Subject: FG/74/20/DOC

Engineers Comments Regarding Surface Water Drainage

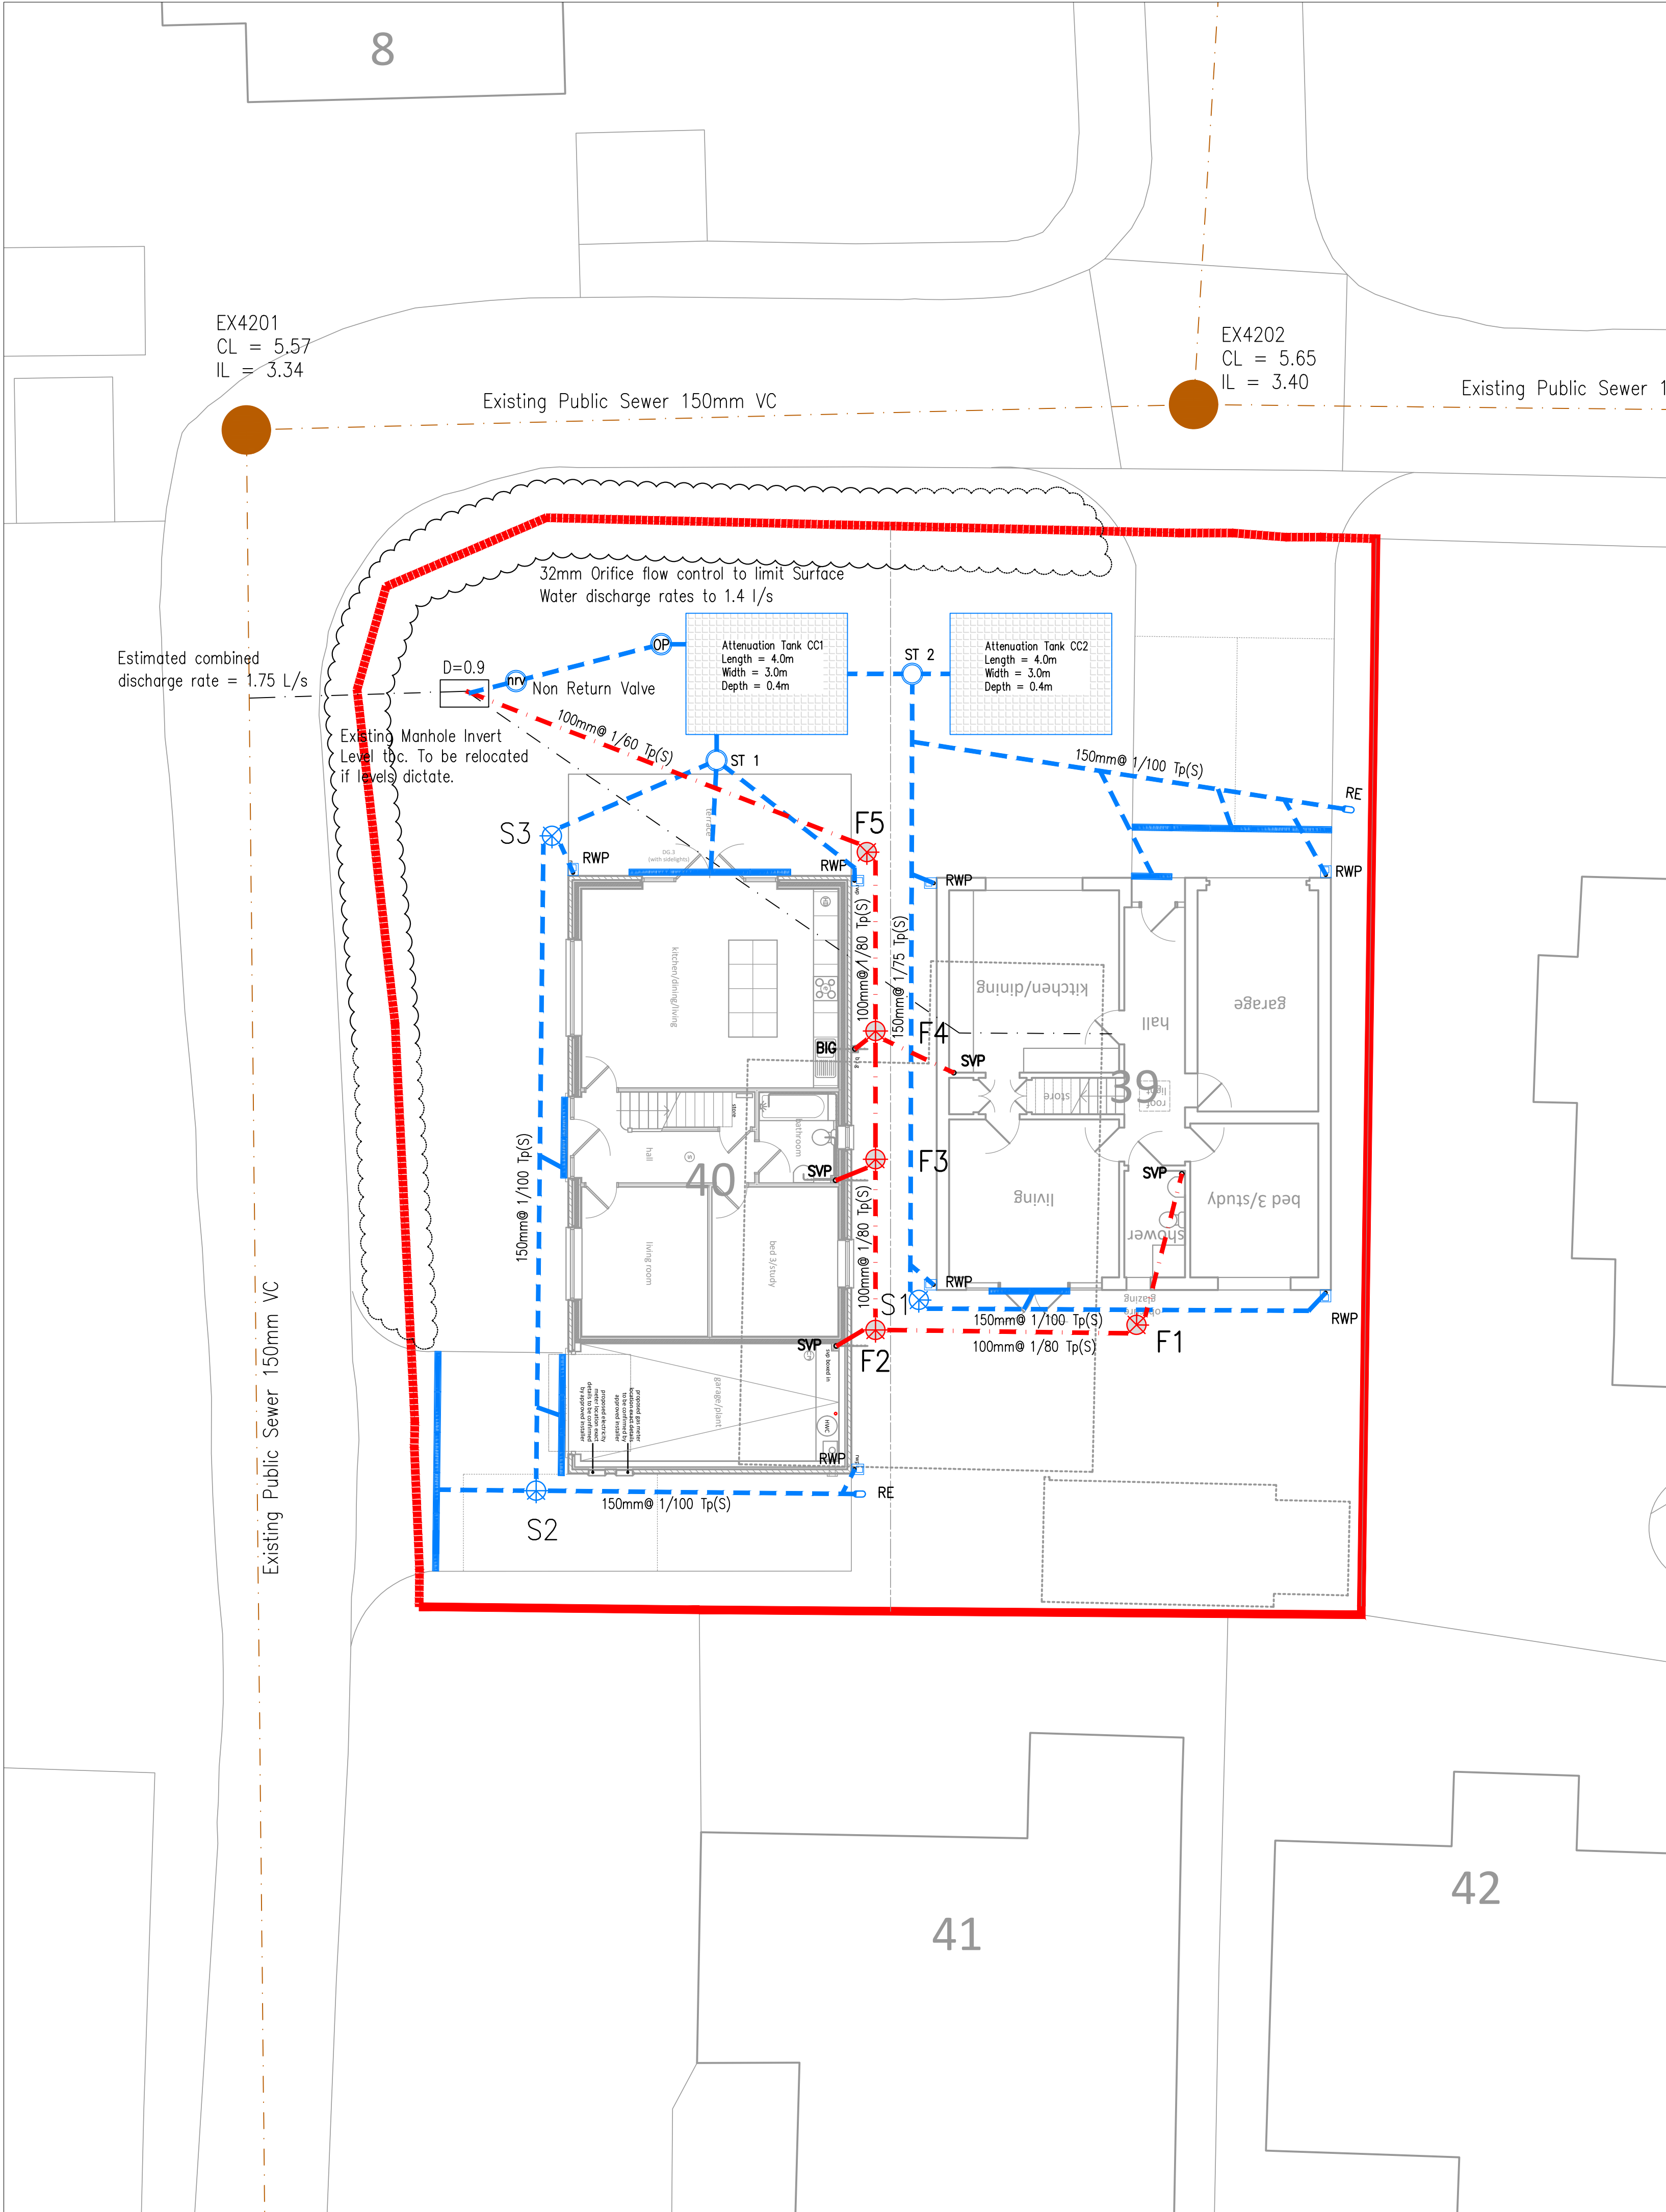
According to our records there are no watercourses or surface water sewers in the vicinity of the site. This means that surface water will likely have to be drained to the foul sewer. We will need to see agreement to this from Southern Water. In addition a capacity check (from Southern Water) will be required to determine the allowable discharge rate from the site. This will need to be submitted to ADC in order to discharge this condition.

1. A detailed drainage layout. This should include:
 - a. Pipes: diameters, material type, gradients/falls, invert and cover levels
 - b. Manholes/inspection chambers, silt traps: Cover types, invert and cover levels. (A silt trap must be provided upstream of an attenuating structure.)

- c. Control structures (if necessary): As b. plus the restricted flow rate and design head.
 - d. Attenuation features: Dimensions, invert and cover levels.
2. Calculations to show the volume of the attenuation structure required as a result of Southern Water capacity check.
 3. Construction detail drawings for all components listed above plus pipe bed and surround.
 4. Agreement from Southern Water to the proposal to discharge surface water to the foul.
 5. A capacity check from Southern Water showing the allowable discharge rate of surface water to the foul sewer.
